Appeal Decision

Appeal Ref: APP/R4408/Z/23/3331190

119 High Street, Wombwell, Barnsley S73 8HS

- The appeal is made under Regulation 17 of the Town and Country Planning (Control of Advertisements) (England) Regulations 2007 against a refusal to grant express consent.
 - The appeal is made by Wildstone Estates Limited against the decision of Barnsley Metropolitan Borough Council.
 - The application Ref 2023/0737, dated 2 July 2023, was refused by notice dated 29 September 2023.
 - The application is for erection of internally illuminated advert measuring 3m x 6m.
-

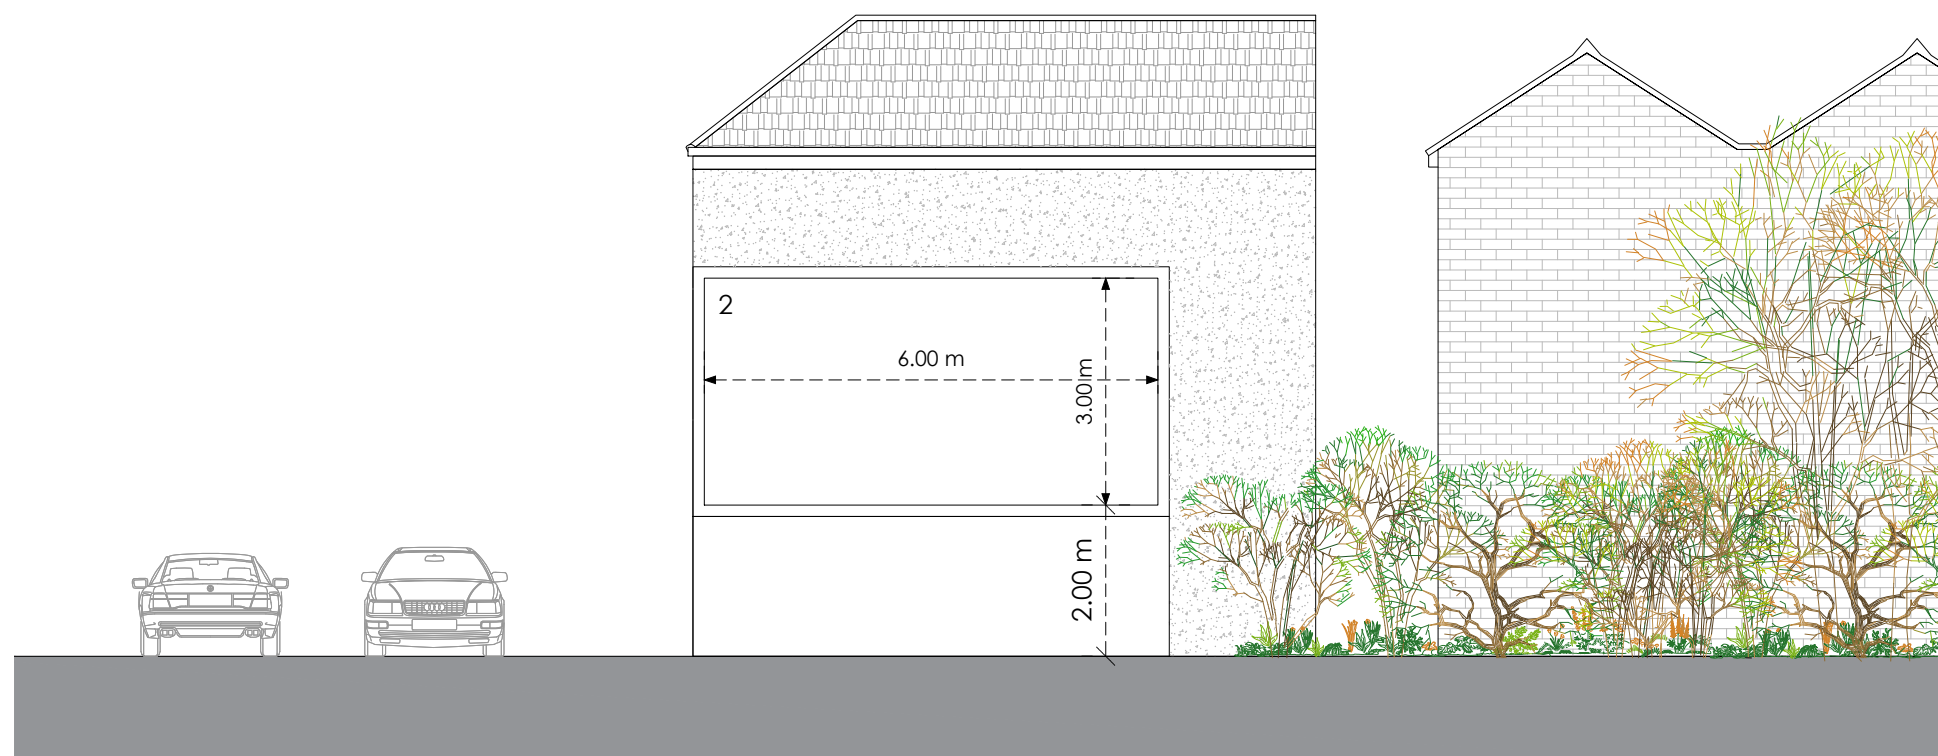
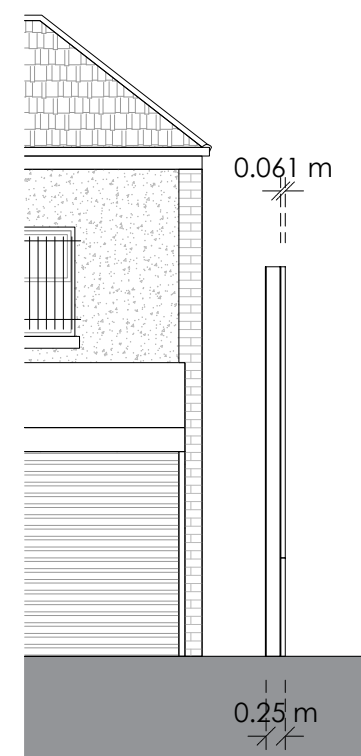
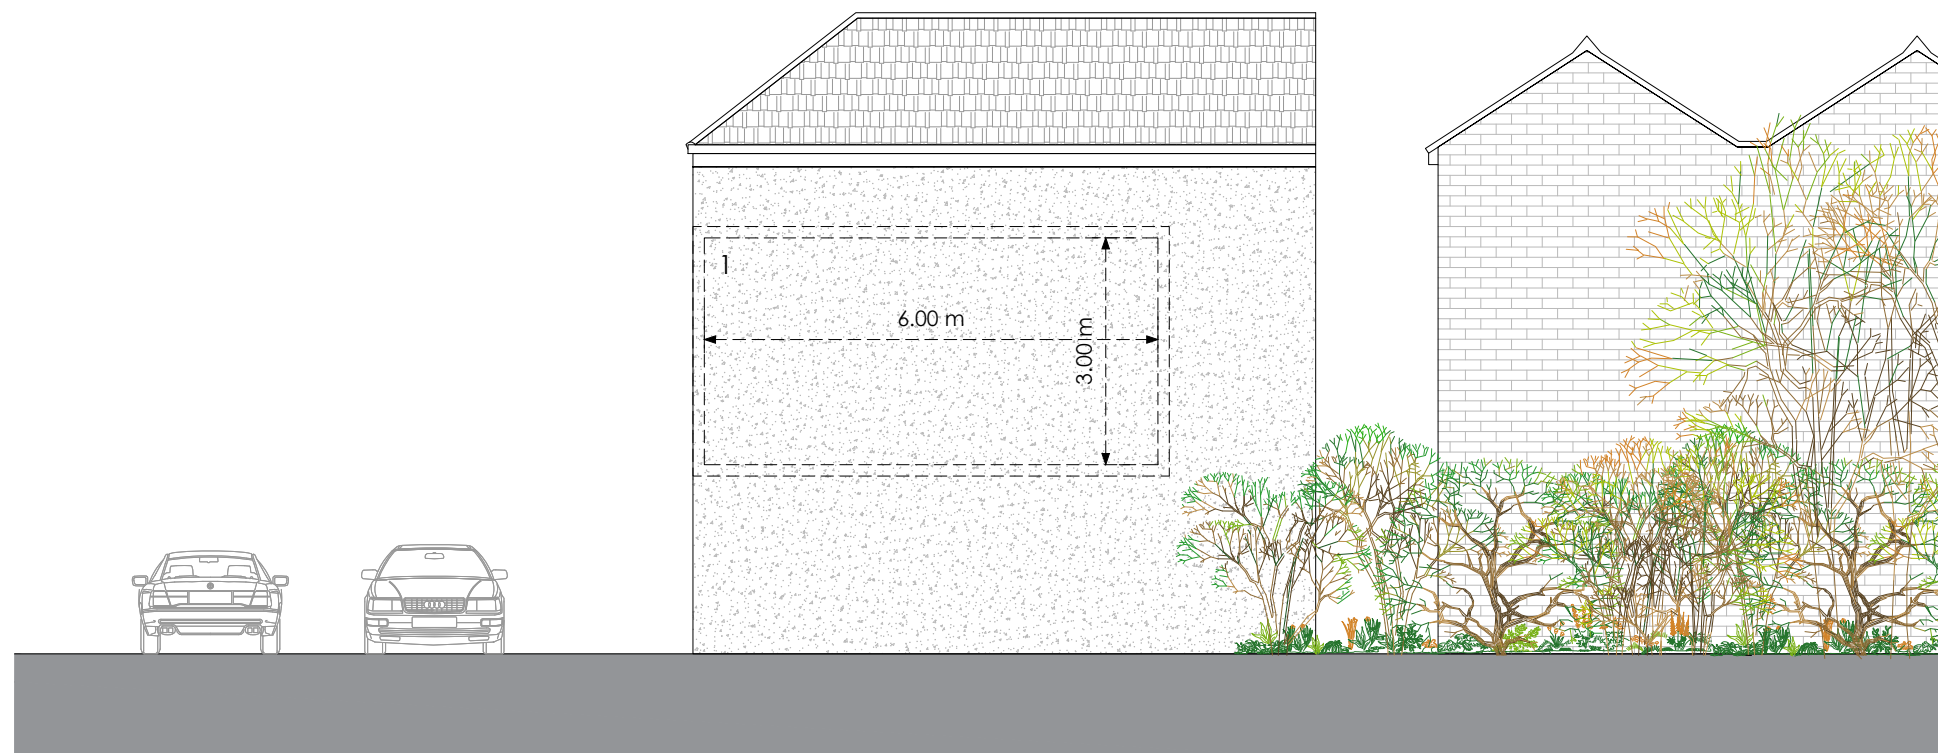
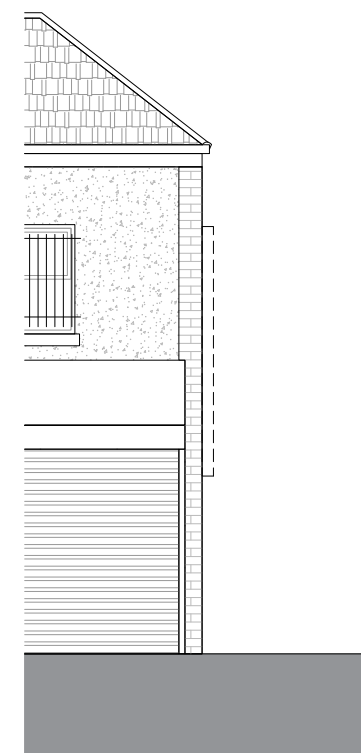
5. The proposal before me seeks permission for an internally illuminated advertisement to be placed upon the end elevation of a commercial property within the edge of the local district centre of Wombwell. The proposed hoarding would be around 3 metres in height and 6 metres in length and would be affixed near to the front edge of the property around 2 metres higher than the existing ground level.
6. The appeal property is currently absent of any such advertisement hoarding and instead, I saw on my site visit, that it is painted a dark, near black colour,

10. In considering the impact of this, I consider that the dominance, illumination and size and scale of the proposed advert would cause some noticeable harm to the character and appearance of this part of the townscape and would tend to dominate the more human scale commercial uses that tend to predominate here.

11. Despite the presence of an older paper and paste hoarding to this elevation therefore, I consider that the changing display, illumination (albeit low) and the absence of such other hoardings in this area would make this proposal all the more harmful and prominent within this location and in relation to its neighbours.
